Your Ref: OWPC24624
Our Ref: EP/116/19/CLP
Please ask for:
Mr R Castro-Parker

16th October 2019

Application for certificate of lawfulness for proposed works - replacement of existing thatched roof with clay tiles & replacement of 2no. existing bay windows
29 Tamarisk Way East Preston

LAWFUL DEVELOPMENT			
Elevations as proposed			
date: Aug 19			
scale: 1:100@ A1	1905	AL	(0-) 06

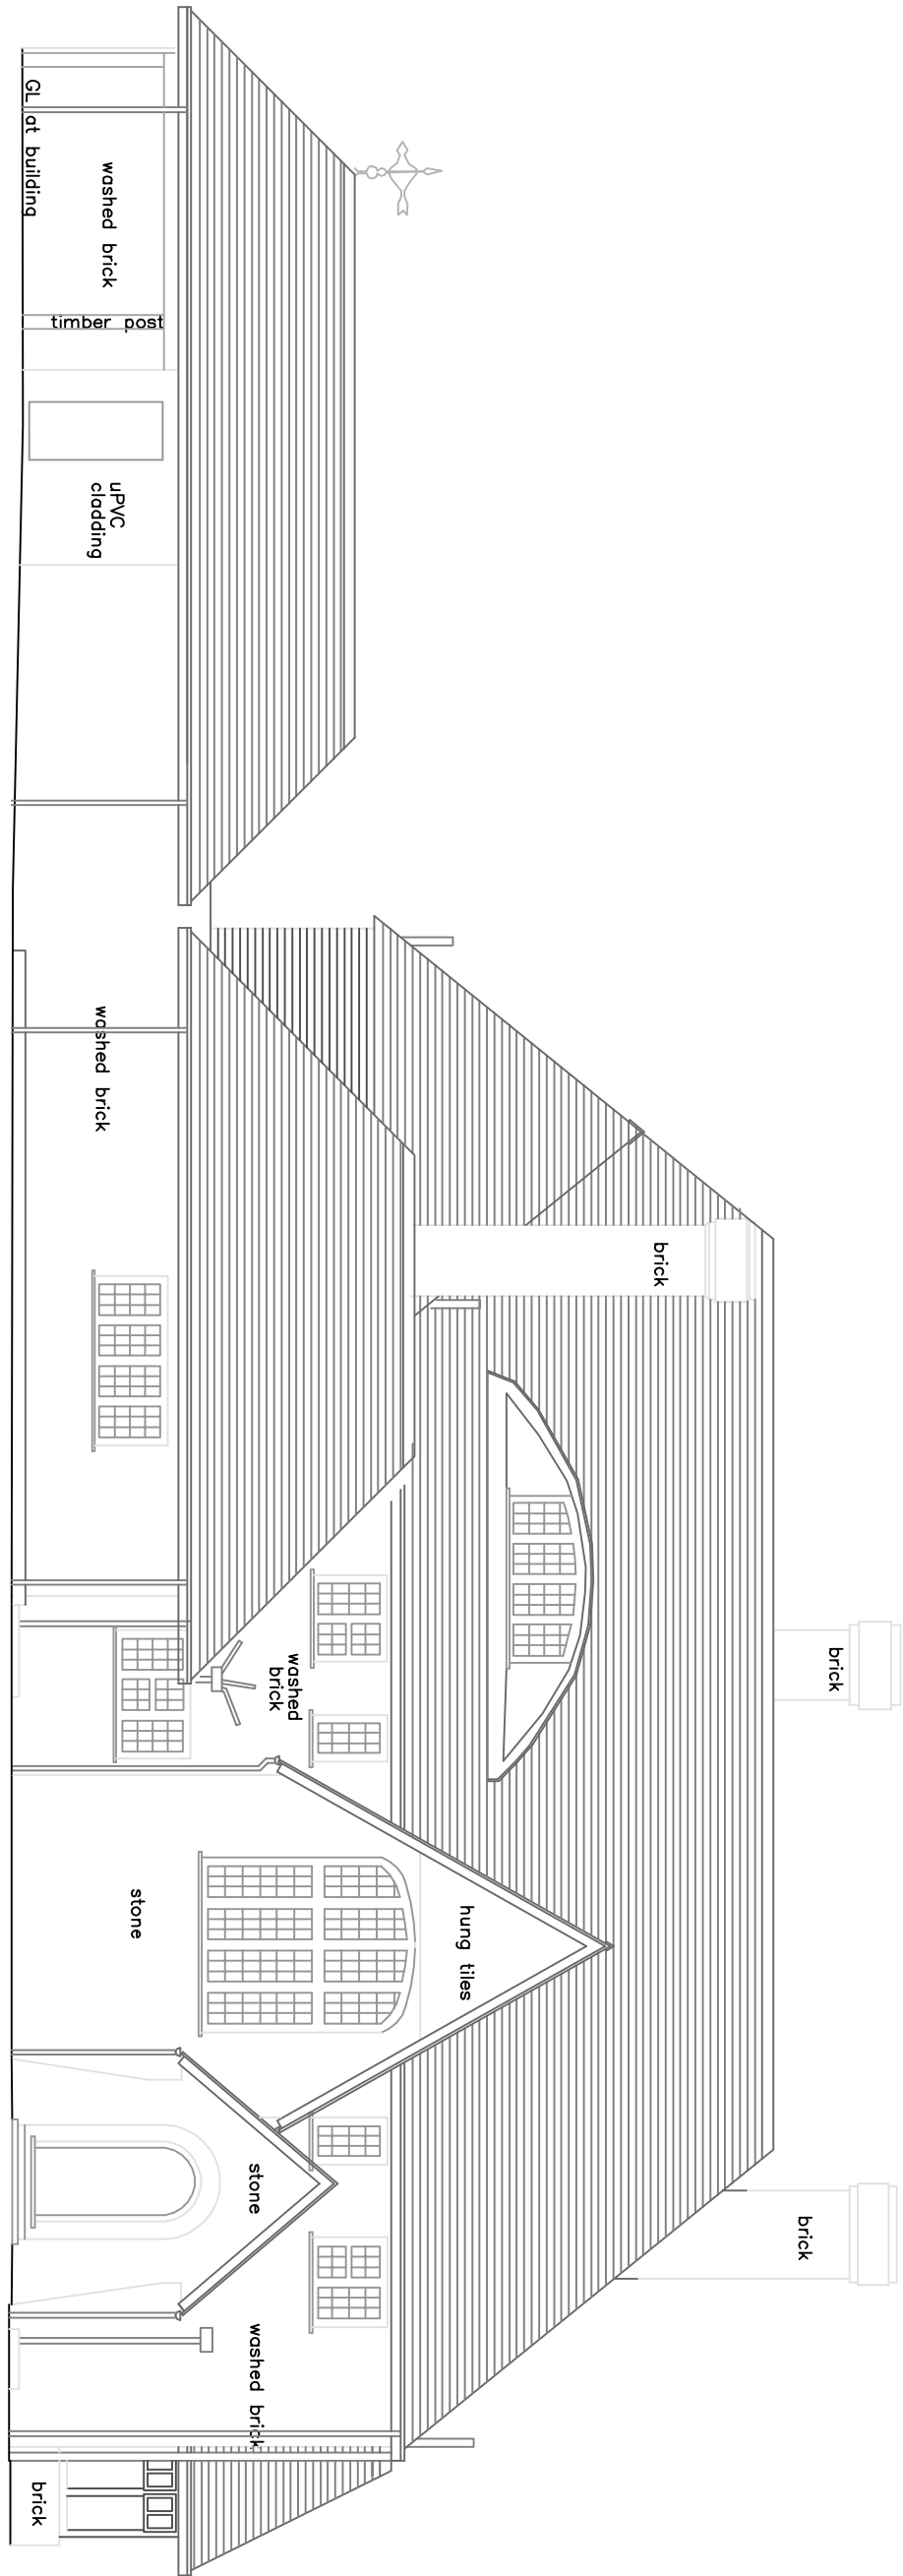
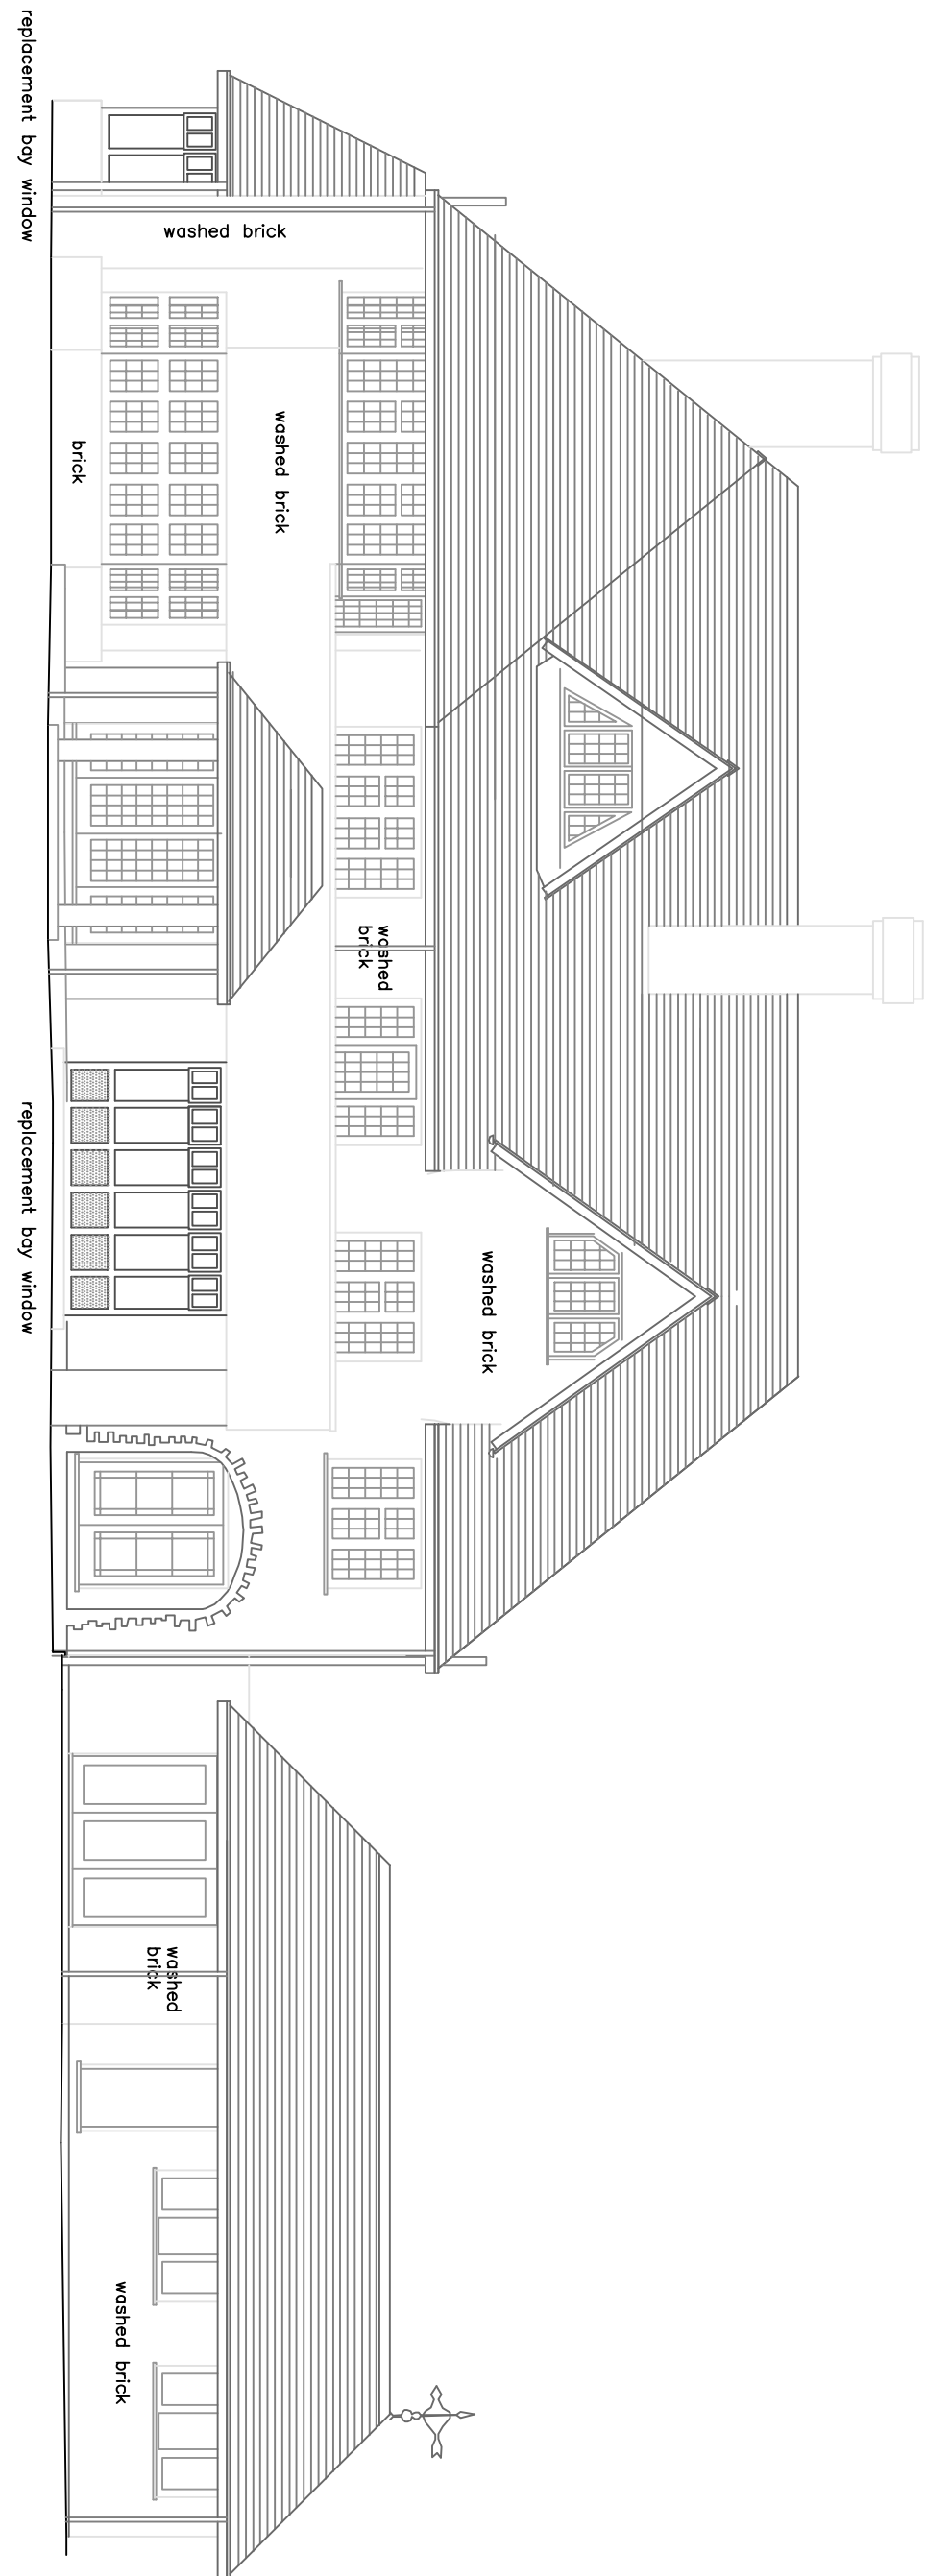
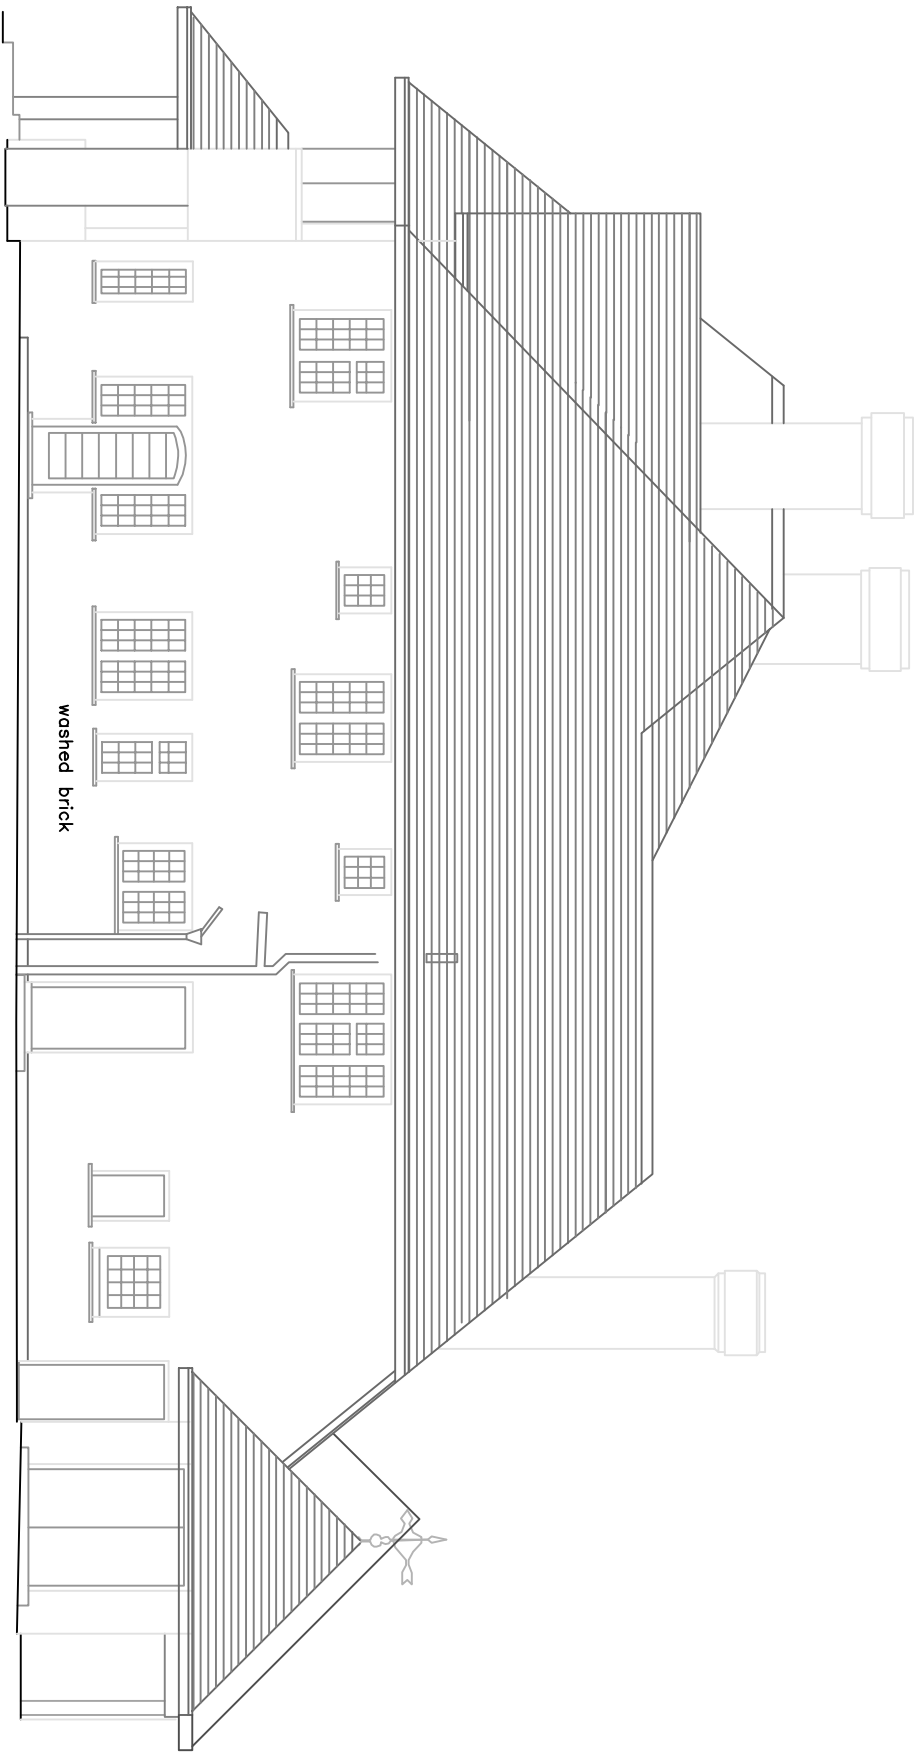
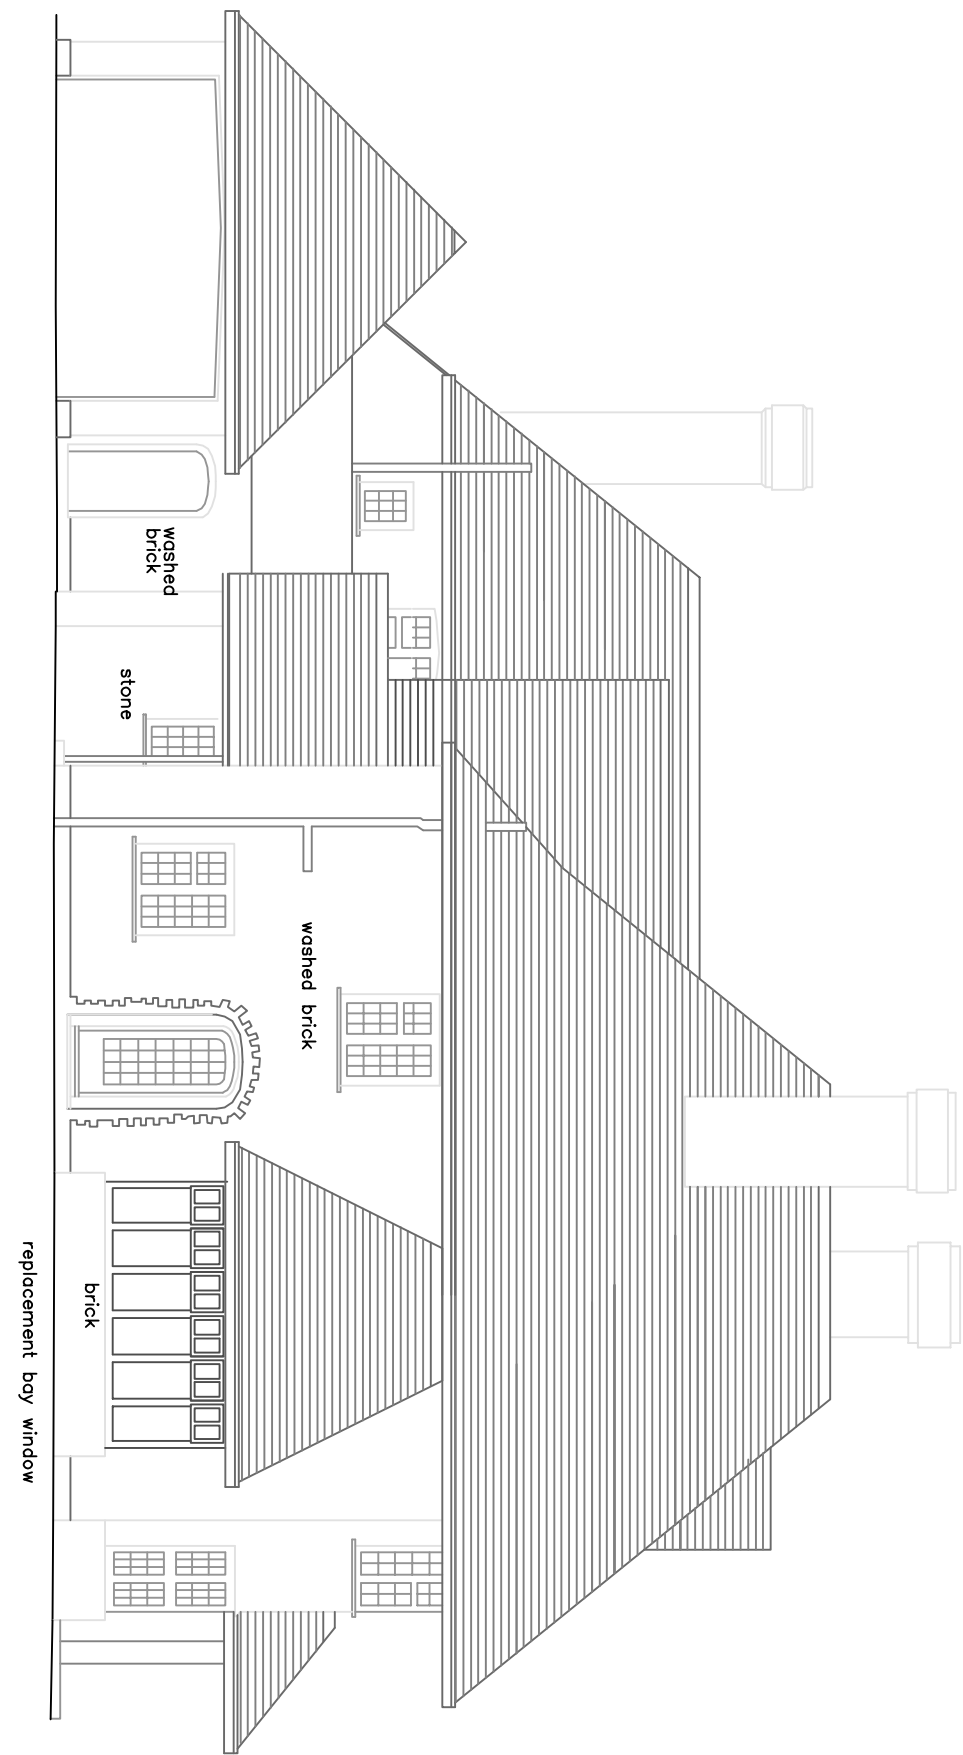
The property is on Arun District Council's Local List and is therefore covered by the Local Plan Policy HER DM2. The committee believed the proposals for this property conflict with the policy as they do not "relate sensitively to the building or structure and its setting and respect its architectural, landscape or historic interest." The committee felt the proposals risked losing the character of this building which, as previously stated, has been considered important enough to appear on the ADC Local List.

If at all possible, this council would like ADC to refuse Planning Permission for the change of roofing materials. Although not visible to the general public, the committee also felt the replacement for the bay windows on the southern and western elevations were out of keeping with the fenestration of the rest of the building.
